CITY OF ALBUQUERQUE

September 5, 2024

**Re: Unser Blvd and Sage Rd Development, 2024
Traffic Impact Study (M10D023)**
DRAFT Study date July 29, 2024
Via email jroberts@tierrawestllc.com

The subject Traffic Impact Study (Study) draft received on August 27, 2024, has been reviewed by the City of Albuquerque Planning Development Transportation Section. The City has the following comments to be addressed.

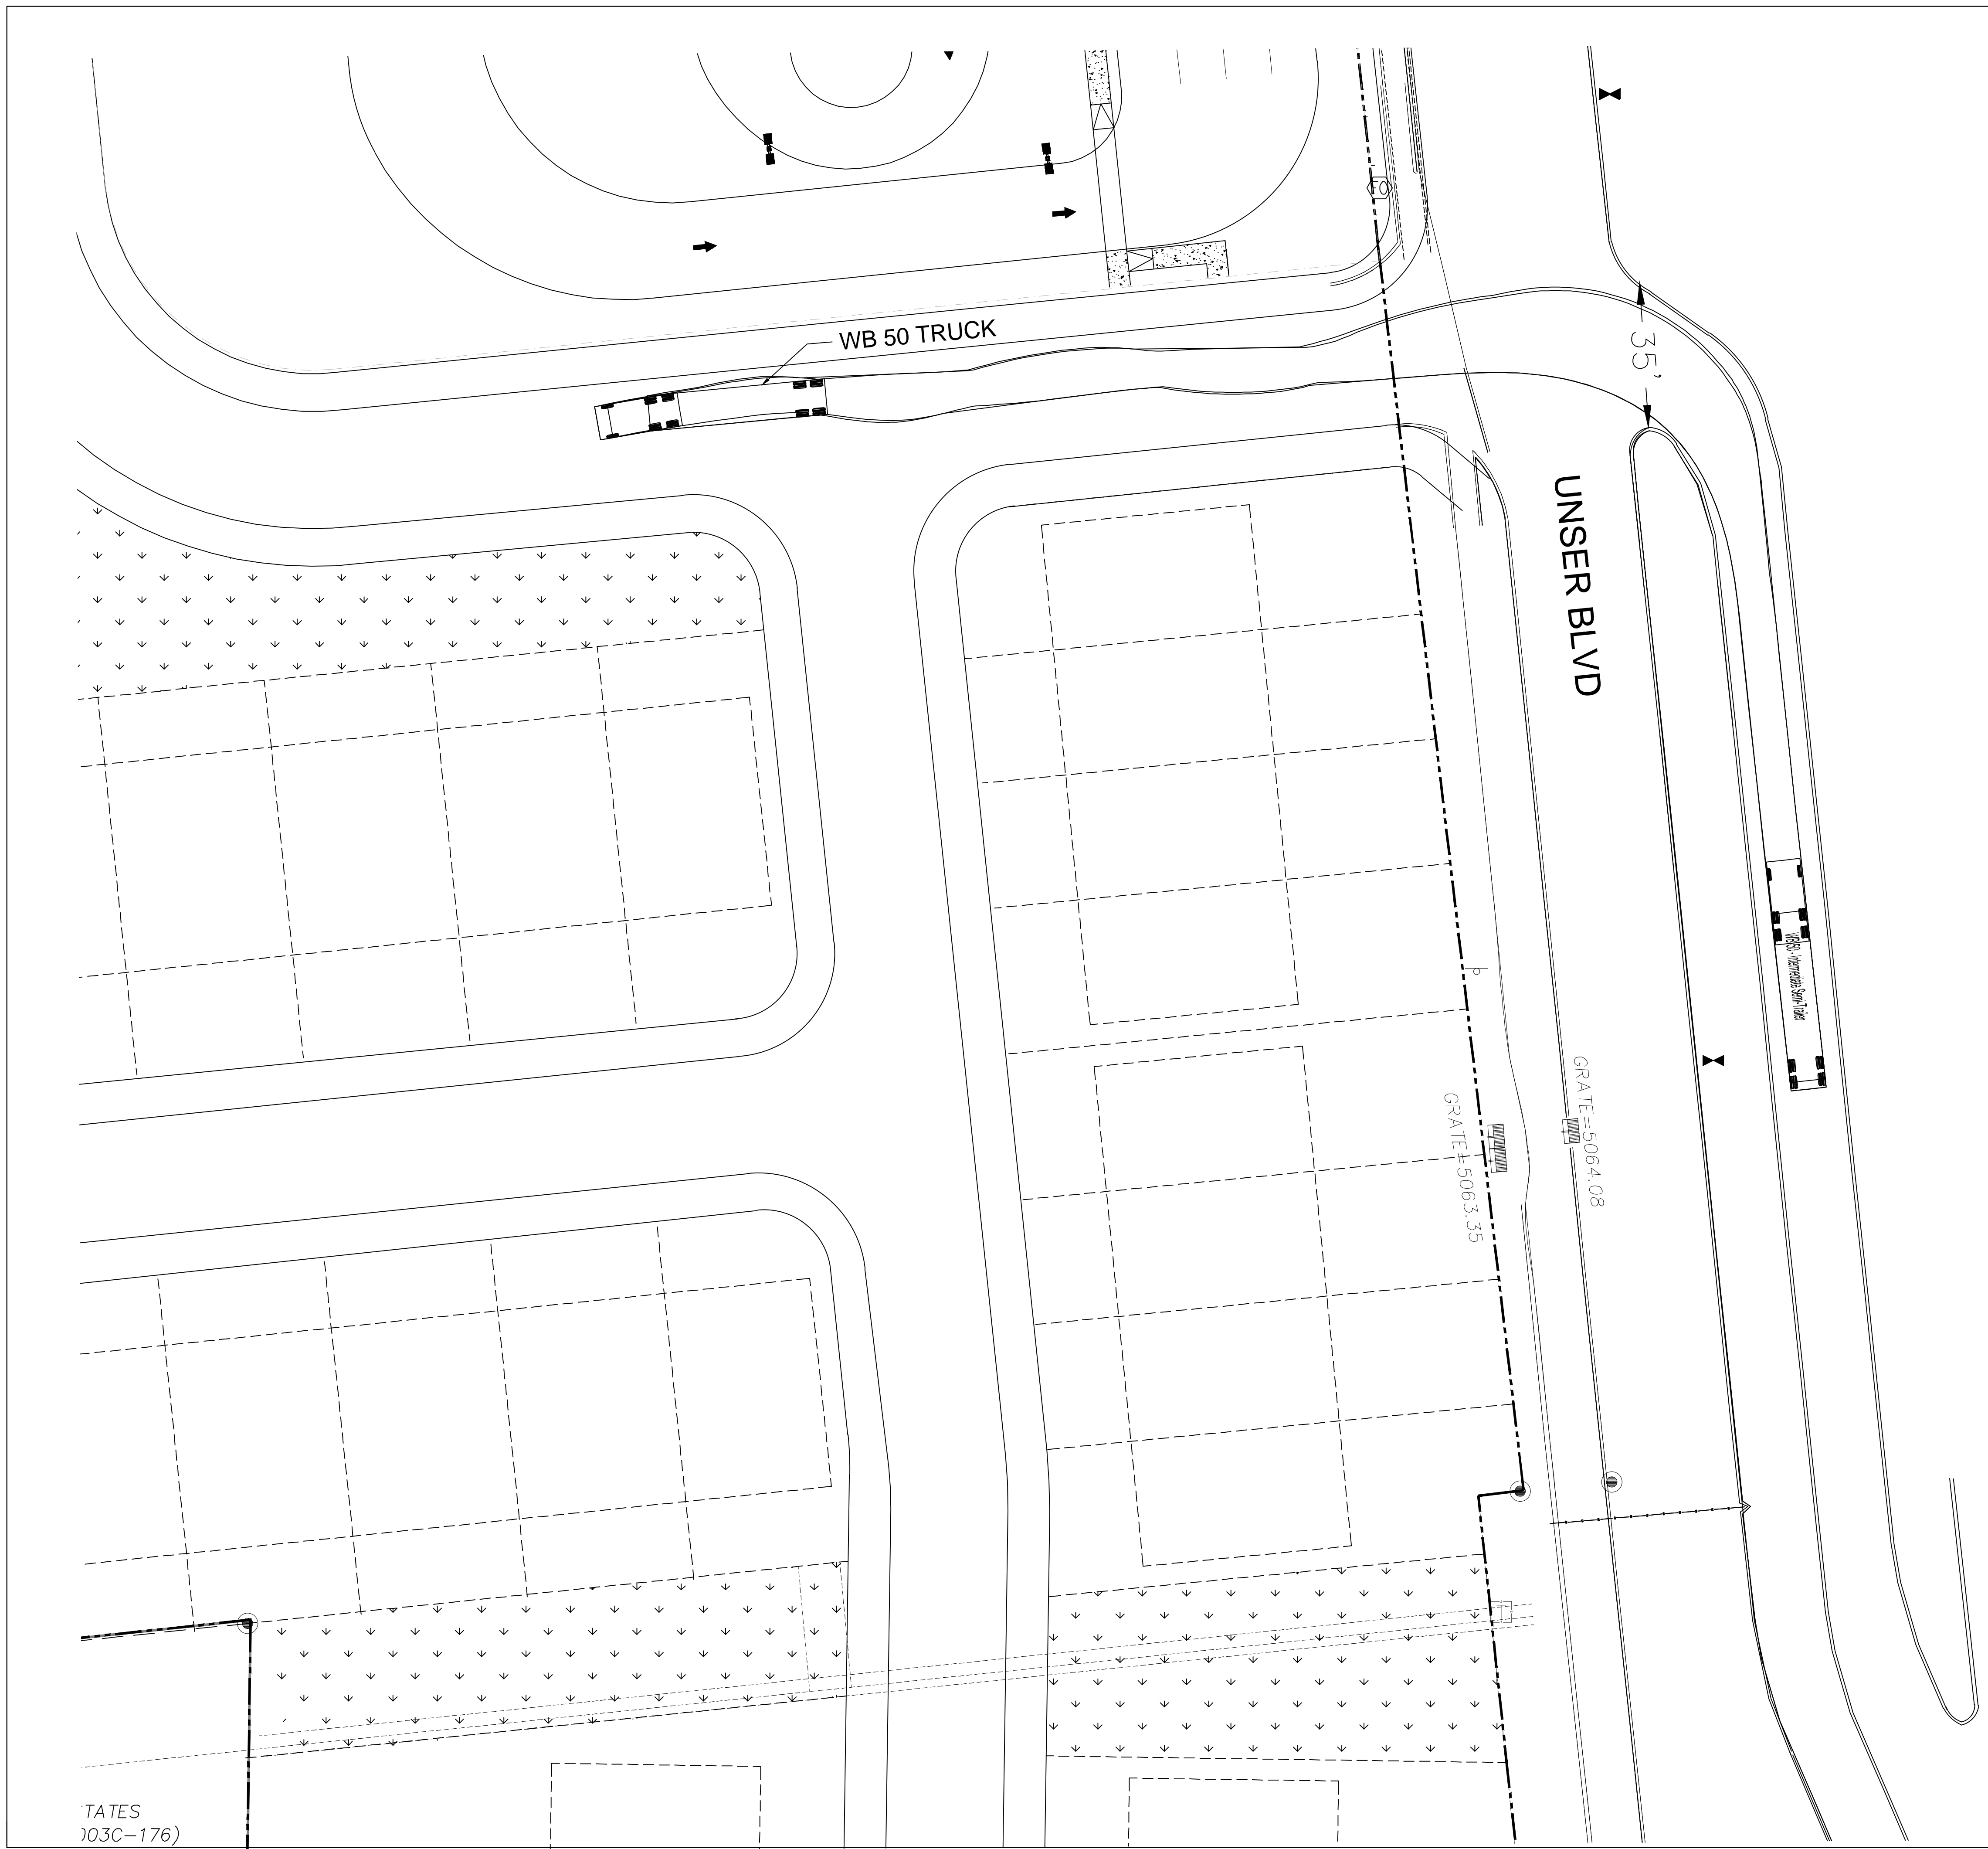
1. For the relocation of the cell tower driveway, what is the plan if the Owner of the easement does not agree to the change?
2. How far is the proposed relocated cell tower driveway from the west property line?
3. The deceleration lane for Driveway B continues into the deceleration lane for driveway C. A driver may enter the deceleration lane for driveway B and not turn into driveway B, while at the same time a driver leaving driveway B may assume this person is turning.

This conflict should be mitigated. One possible way to mitigate this would be to shorten or eliminate the deceleration lane for driveway C. The posted speed limit is 40 mph allowing for a 240' deceleration lane and the current deceleration lane is approximately 360' long. The Study shows the deceleration lane is not warranted.
